Consultation Response from KC, Highways Development Management (HDM)
2025/91731 - Land off Bankfield Drive, Holmbridge, Holmfirth, HD9 2PH
Discharge of details reserved by conditions 12 (pedestrian connection), 13 (cycle parking), 15 (collection of wastes), 21 (Remediation Strategy), 23 (external materials), 24 (windows and doors), 25 (electricity substations), 26 (boundary treatments), 27 (external lighting) on previous permission 2023/91212 for erection of 21 dwellings with access from Laithe Avenue
Date Responded: 12/09/25
Responding Officer: A Darwin
Responding Ref: HDC 3-26/3
RECOMMENDATION:

It is recommended that Conditions 12 & 13 are not discharged at this time.

Date: 20.08.25	PROJECT Barnfield Drive, Hemel Hempstead
Scale & AE: 1:50	Drawing Number: 240000001
Drawn By: CC	Revision: TYPICAL CYCLE STORE DETAIL

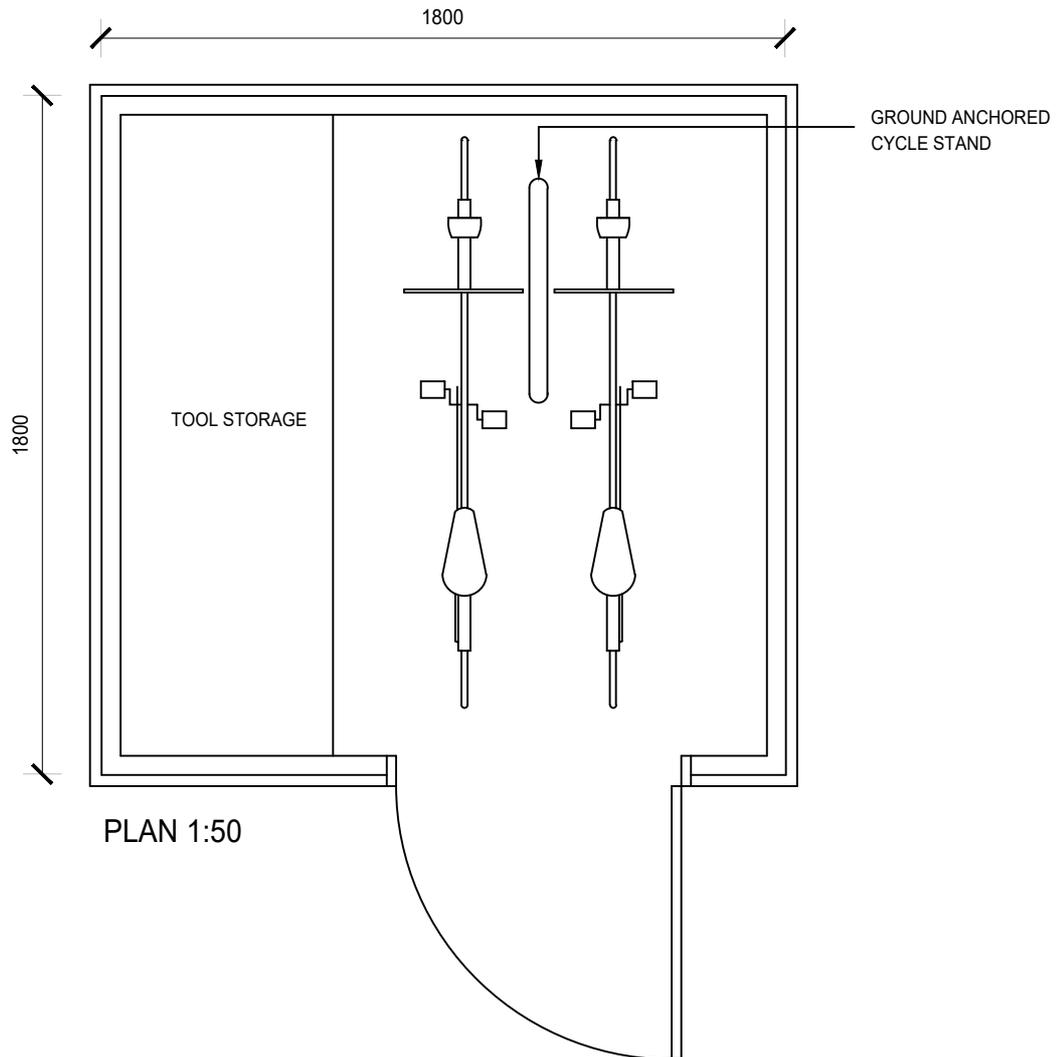
Drawing 2400-02-07 has been submitted to discharge Condition 13. However, the information is not currently acceptable for the following reasons:

- The drawing shows a shed with internal dimensions of 1.8x1.8m, which is insufficient to accommodate larger bikes. In accordance with LTN 1/20 (Table 11-2), a minimum length of 2m is required for floor standing cycle storage. Therefore, a larger shed is required. The shed should also be sufficiently sized to accommodate other essential items (e.g. garden tools/equipment) and include doors that will allow easy access to the cycle storage (e.g. the photo image shows a shed with wider doors than shown on the plan).

- Drawing 2400-02-07 includes a reference to drawing 2400-002-01 that it suggests indicate cycle store locations. However, this plan has not been submitted with this DoC application, and other submitted plans (e.g. 2021.01.003X and 2405-03-001A) show conflicting information that doesn't appear to correspond to the proposed cycle shed design. Therefore, a plan is required that shows the correct size/location of the cycle storage. The plans should also confirm the specific dwellings where cycle storage is intended within garages (i.e. where an additional shed may not be required).

In light of the above, it is recommended that Condition 13 is not discharged, until satisfactory details have been submitted and agreed.

JOB No	DRG No	REV
21043	138	A

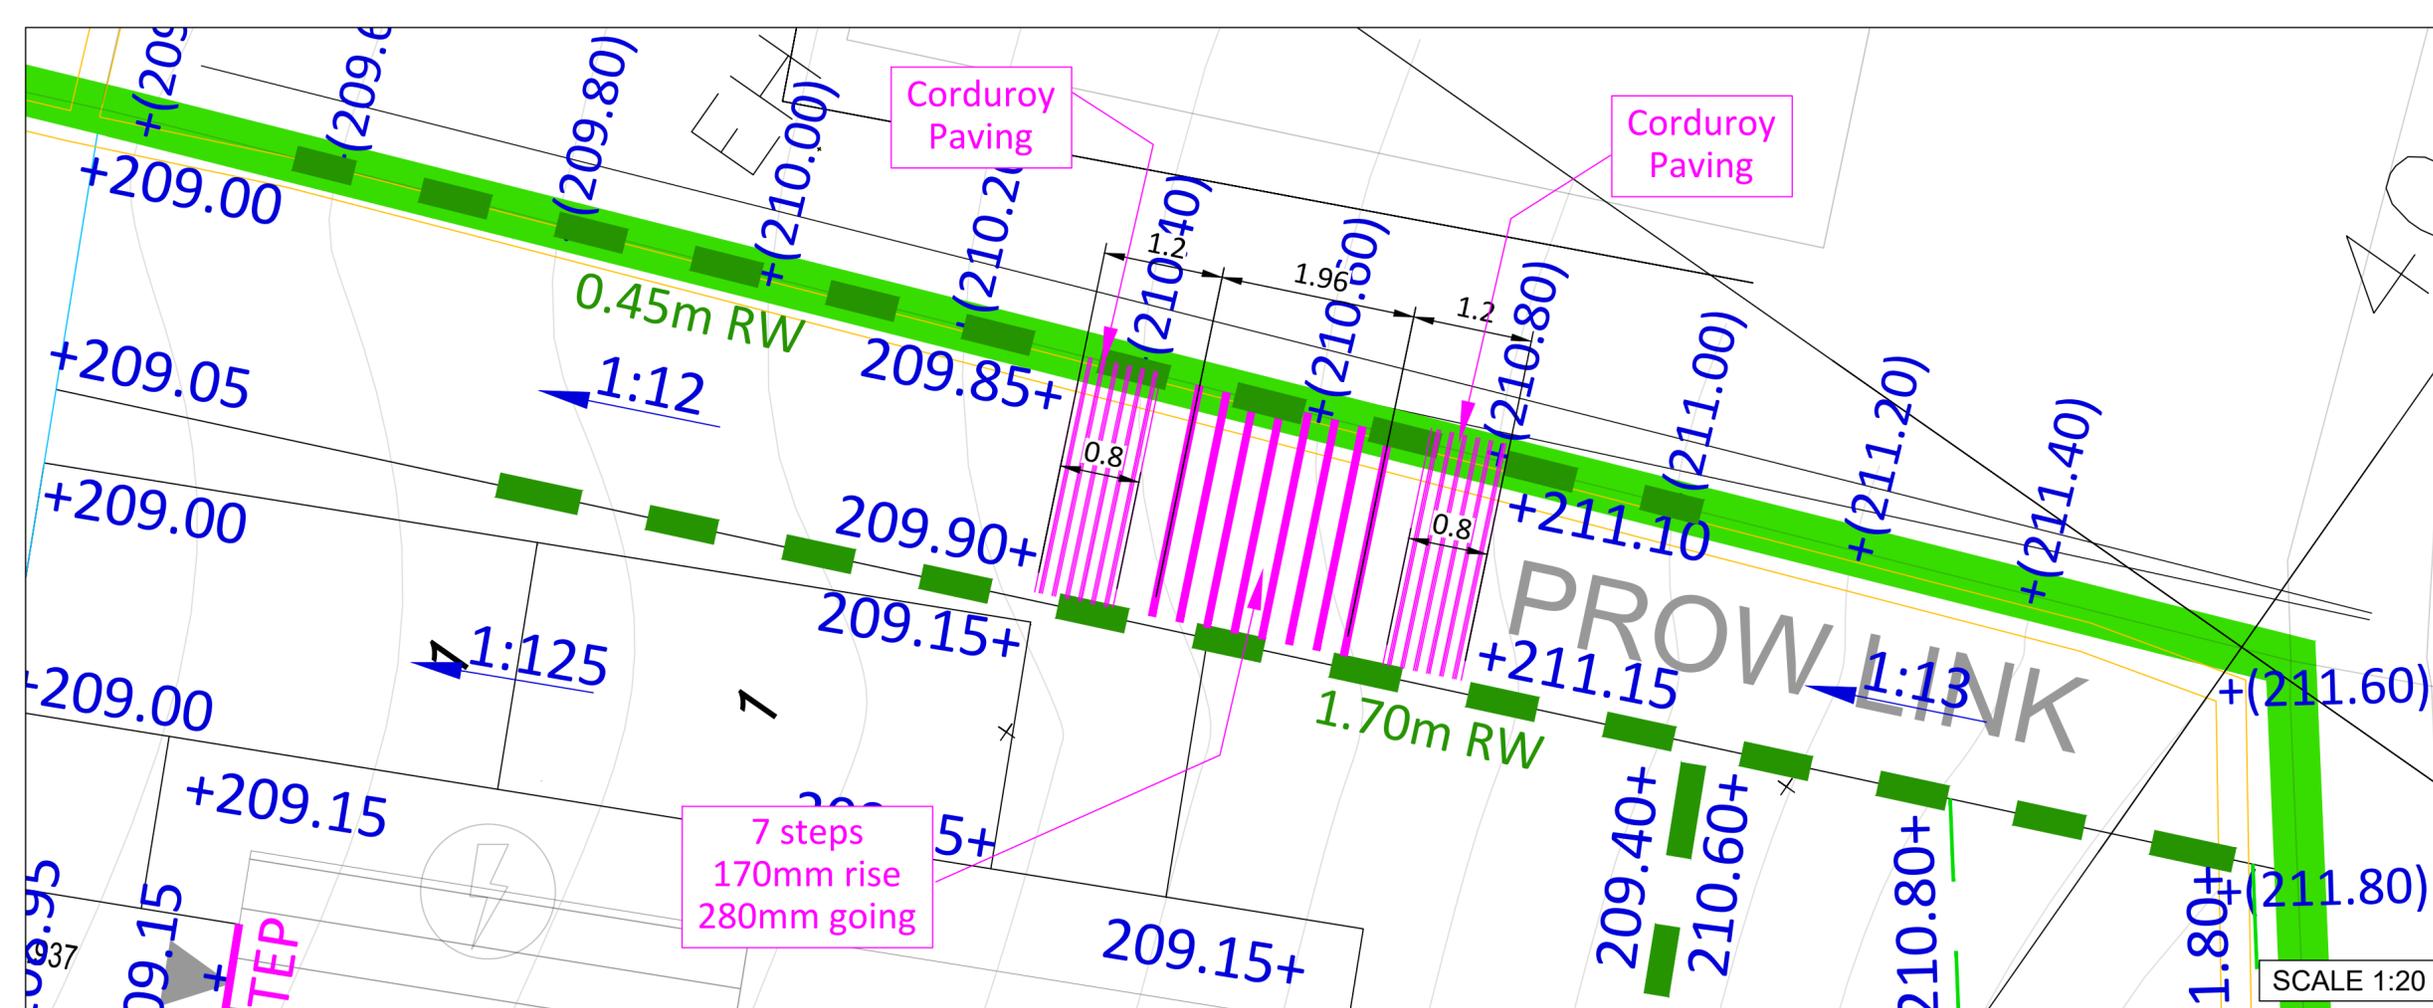
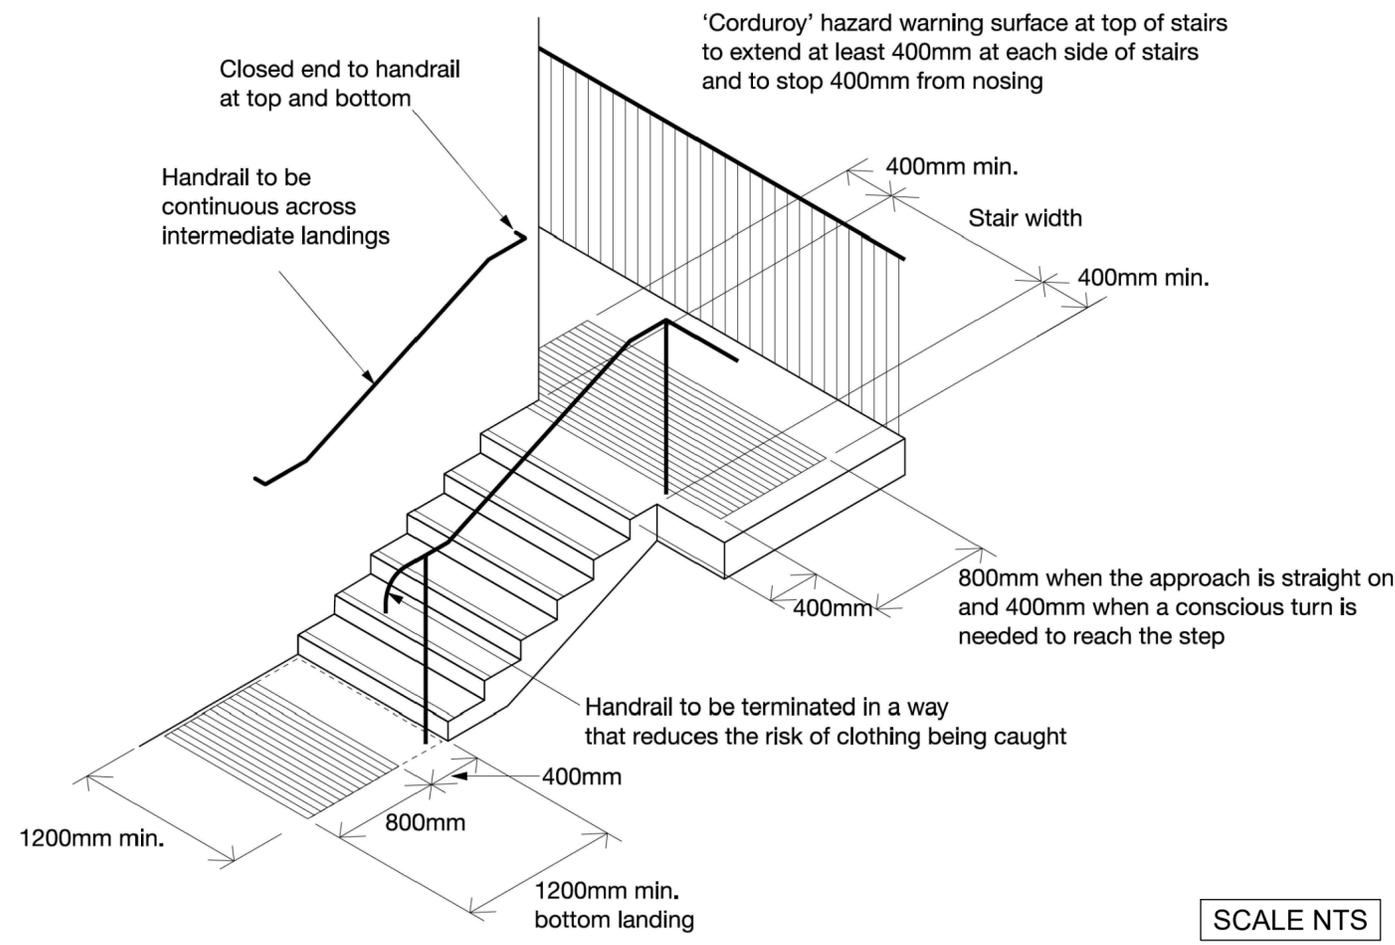
Drawing 2405-03-005 PROW has been submitted to discharge condition 12, which shows a new 2.5m wide footpath connection linking the proposed estate road to PROW HOL91/20.

Whilst the proposed link is in accordance with the preliminary alignment previously agreed, the submitted drawing is lacking in detail and is not currently acceptable, with the following issues identified:

- There is a lack of level information along the boundaries of the proposed pedestrian connection and the adjacent land. Therefore, further details are required, which must confirm that the works will tie-in appropriately with the adjacent property boundaries and land levels (both existing and proposed), the existing PROW levels and the proposed estate road / footway.

- Notwithstanding the lack of detailed level information, it appears that there may be a significant level difference (over 1m) between the pedestrian connection and the rear garden of the proposed dwelling. Should this be the case, a new highway retaining structure may be necessary, which would be subject to approval by the Highway Authority (details also to be approved via planning condition 17). Ideally, the need for any highway retaining structure(s) should be designed out. However, these requirements should be discussed further with the Highway Authority once further design development has been undertaken and the levels are better understood.

- The proposed pedestrian connection includes a number of steps to ensure that a maximum ramp gradient of 1:12 is achieved. Whilst this is acceptable in principle, the location of the steps mid-way along the route are not ideal, as the steps may create a trip hazard given that it is anticipated that the route would be unlit. Therefore, it may be preferable to locate the steps closer to the proposed estate road, where street lighting will be present. That said, it is acknowledged that the location of the steps may be determined by the adjacent tie-in levels along the boundaries and the current step position may need to be retained.

- Only limited construction details have been provided. Therefore, further details are required, which need to comply with highway adoption standards. This includes full technical details of the path construction, including the steps (and associated features, including metal handrails and hazard warning paving), boundary treatments and levels (existing and proposed), together with all other associated features. A full package of level information, including long / cross sections is also required. It is noted that the boundary treatment details will also be subject to separate approval via the requirements of Condition 26.

- The submitted plan does not include details of the connection to the existing PROW. These details need to be provided, which demonstrate that a level connection will be available, and that a new 1.2m wide

gate will be provided (opening inwards to the new route) to replace the existing boundary wall (which should be made good), with the new gate conforming with BS5709-2018.

The applicant should agree the design and construction details of the pedestrian connection with the Councils S38 Team as part of the technical review process. Once this agreement has been reached, these details should be resubmitted to discharge condition 12.
